Response to Submissions

Prepared for: **Grand Noble Project 1 Pty Ltd**

The State Significant Development Application (SSD-96272465) for residential development with in-fill affordable housing at 11–23 Rangers Avenue, Mosman was publicly exhibited between 4 December 2025 and 17 December 2025. During the exhibition period, a total of 185 submissions were received.

2. HEIGHT PLANE - SOUTH-EASTERN CORNER

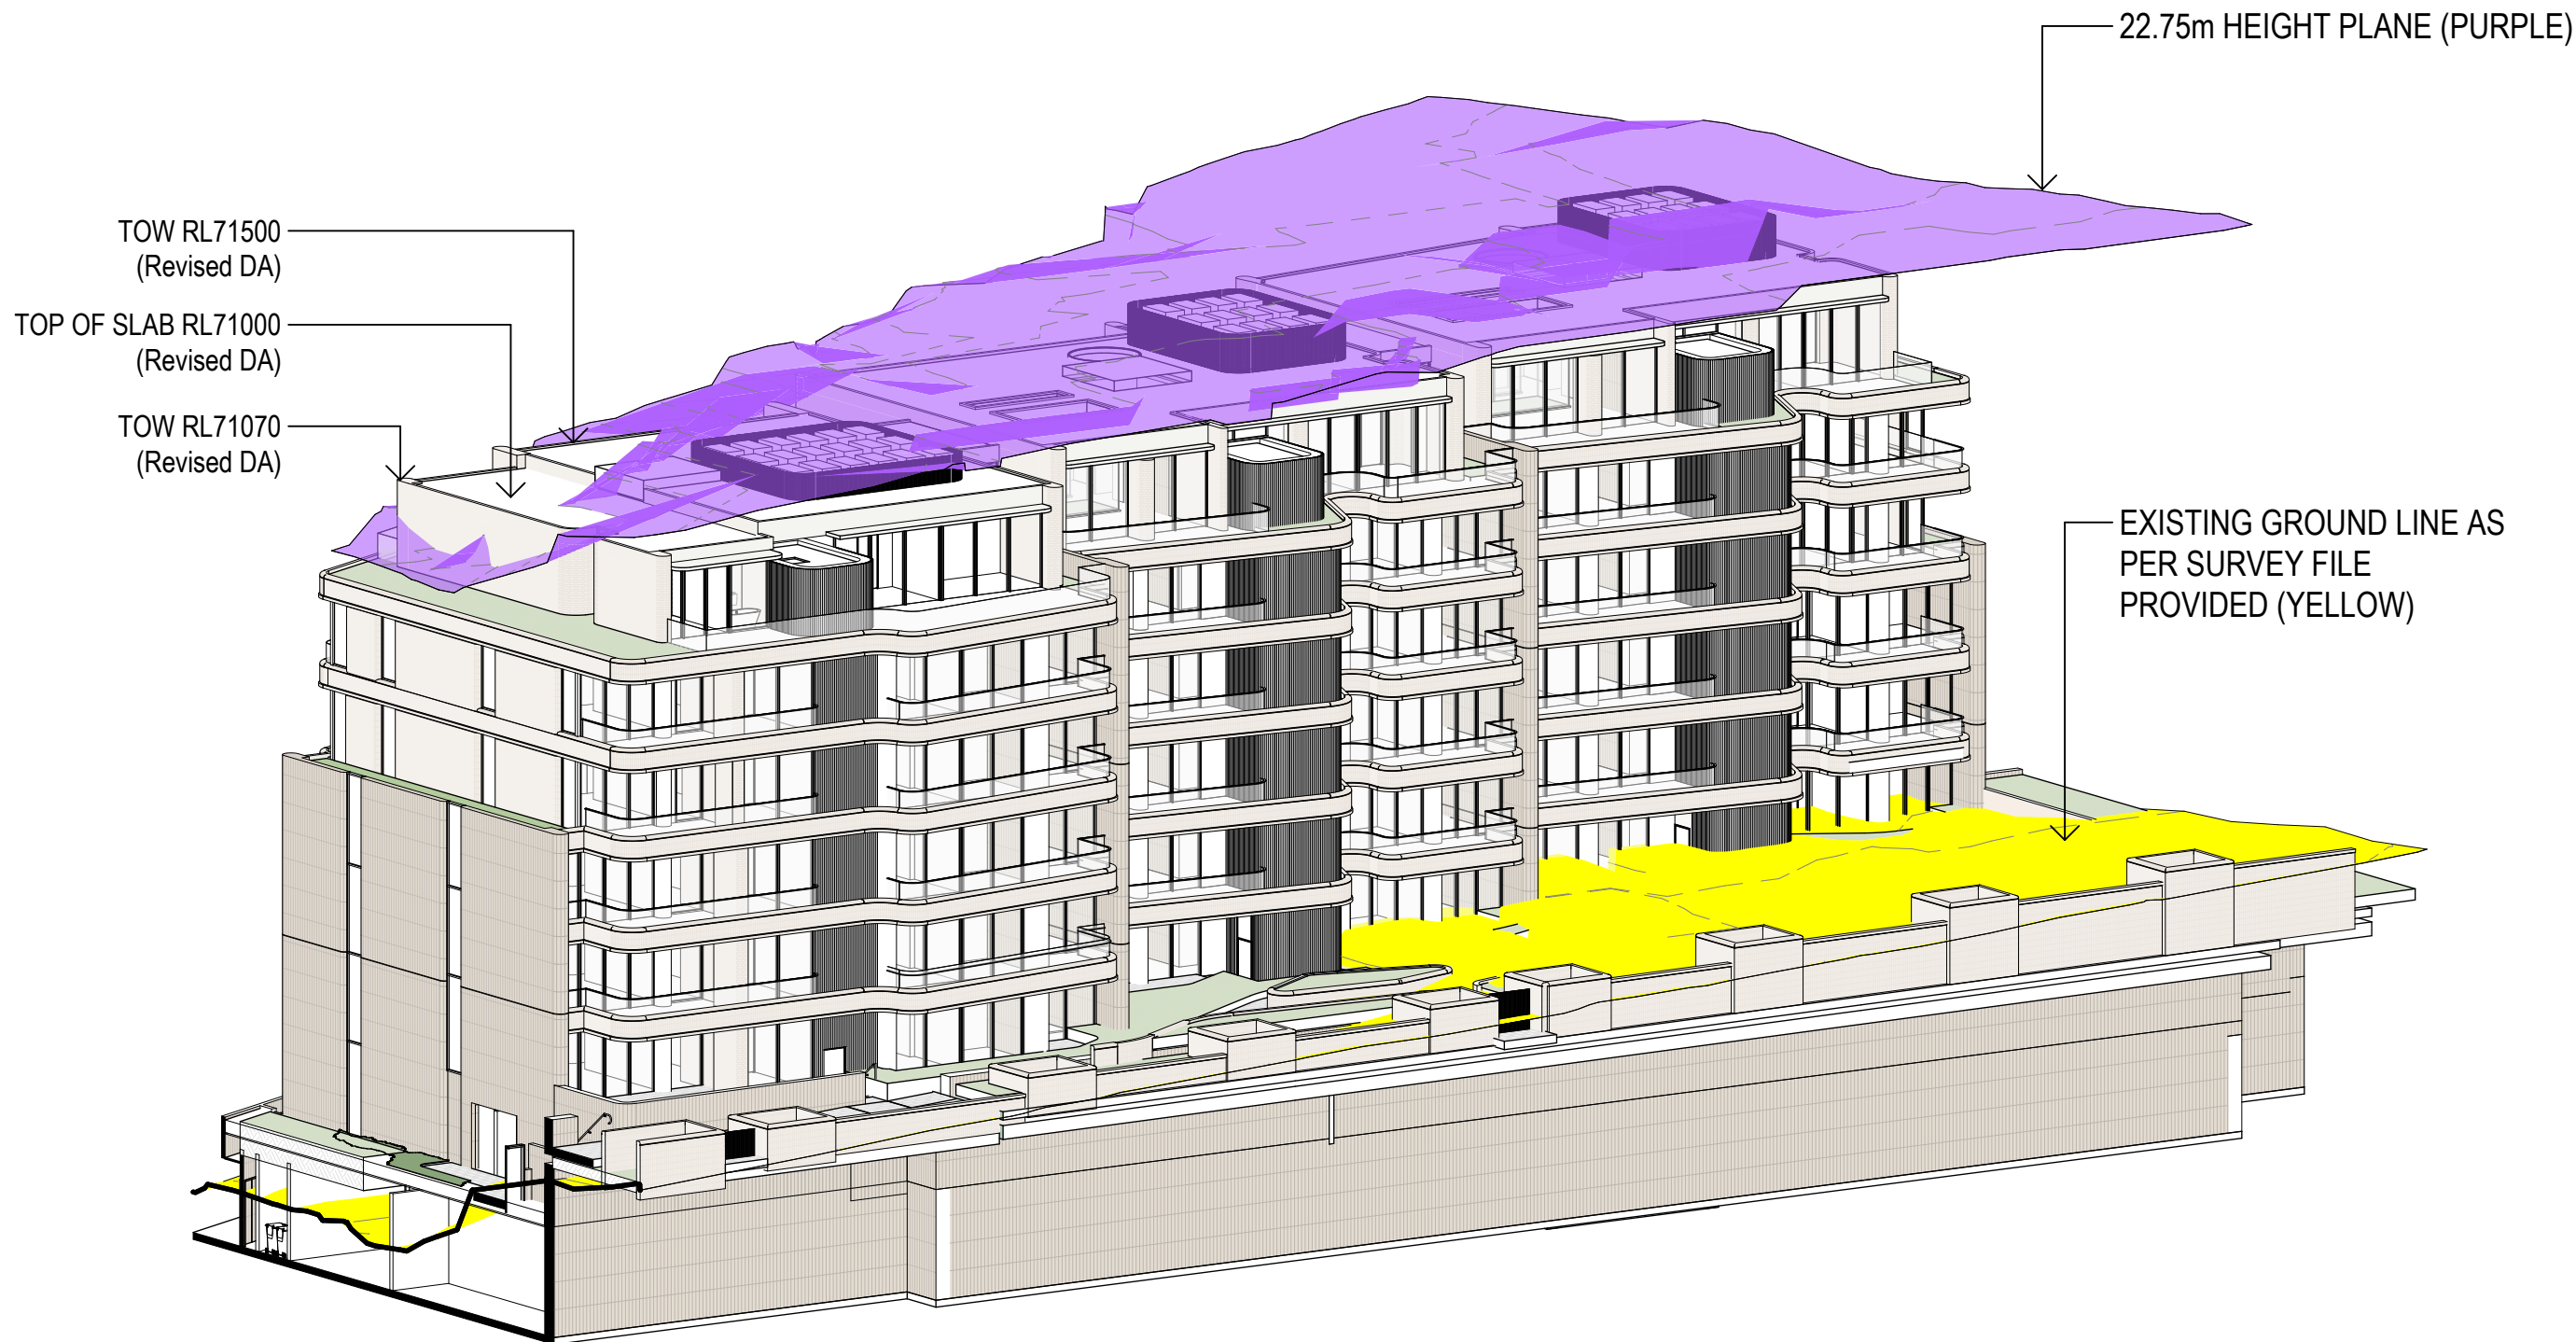
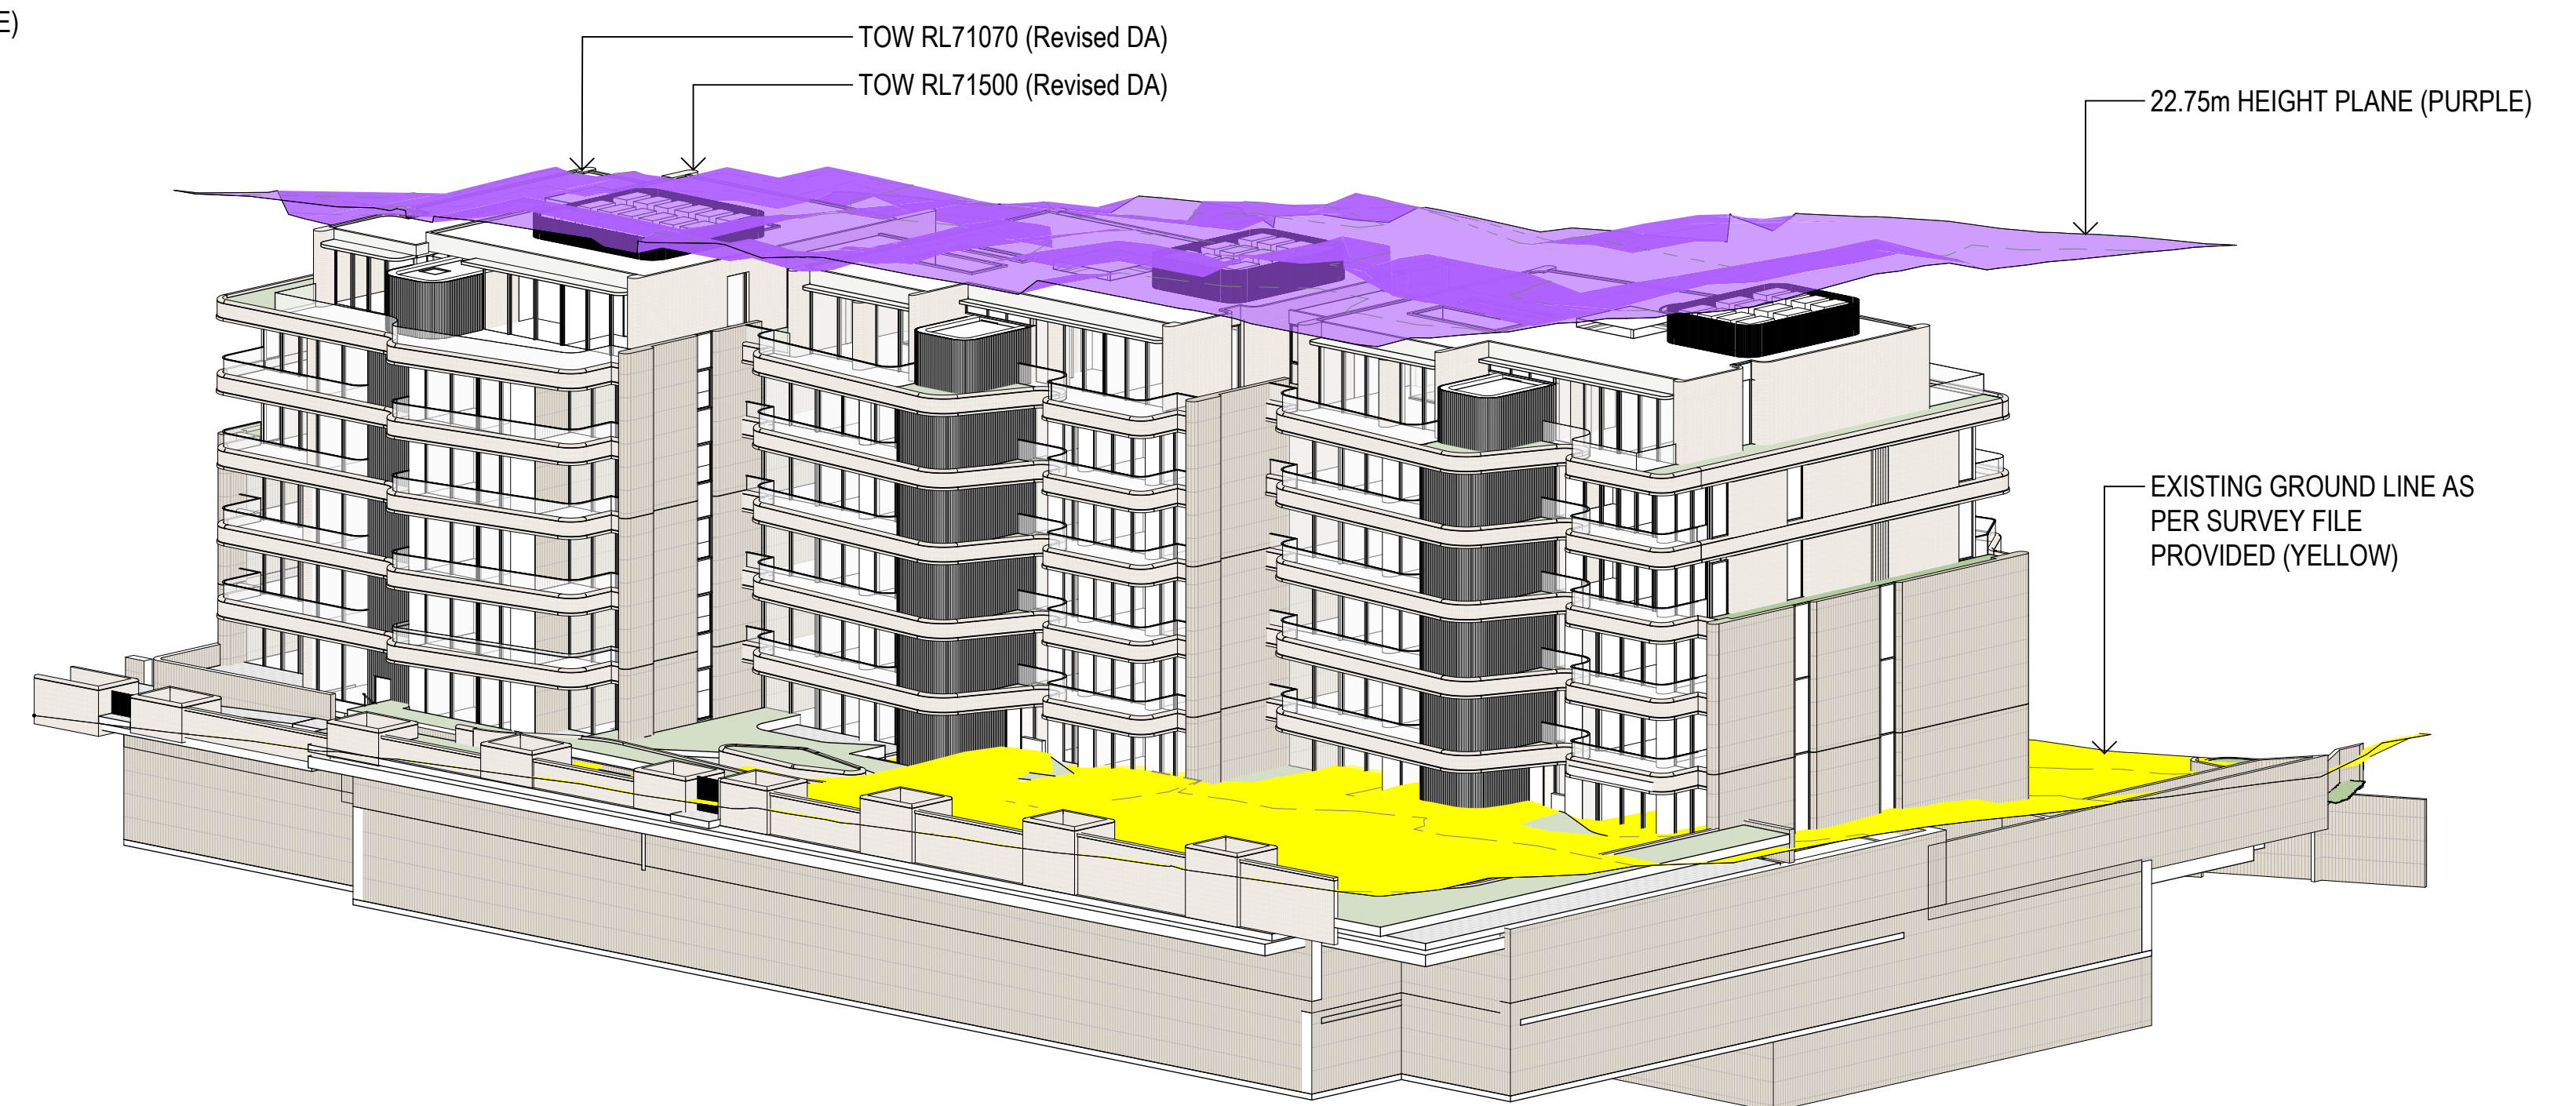
- Identifies non-compliance with building height and wall height controls, stating the development exceeds the maximum height even with the affordable housing uplift, and contending the proposal’s height presentation is amplified by slope and excavation.
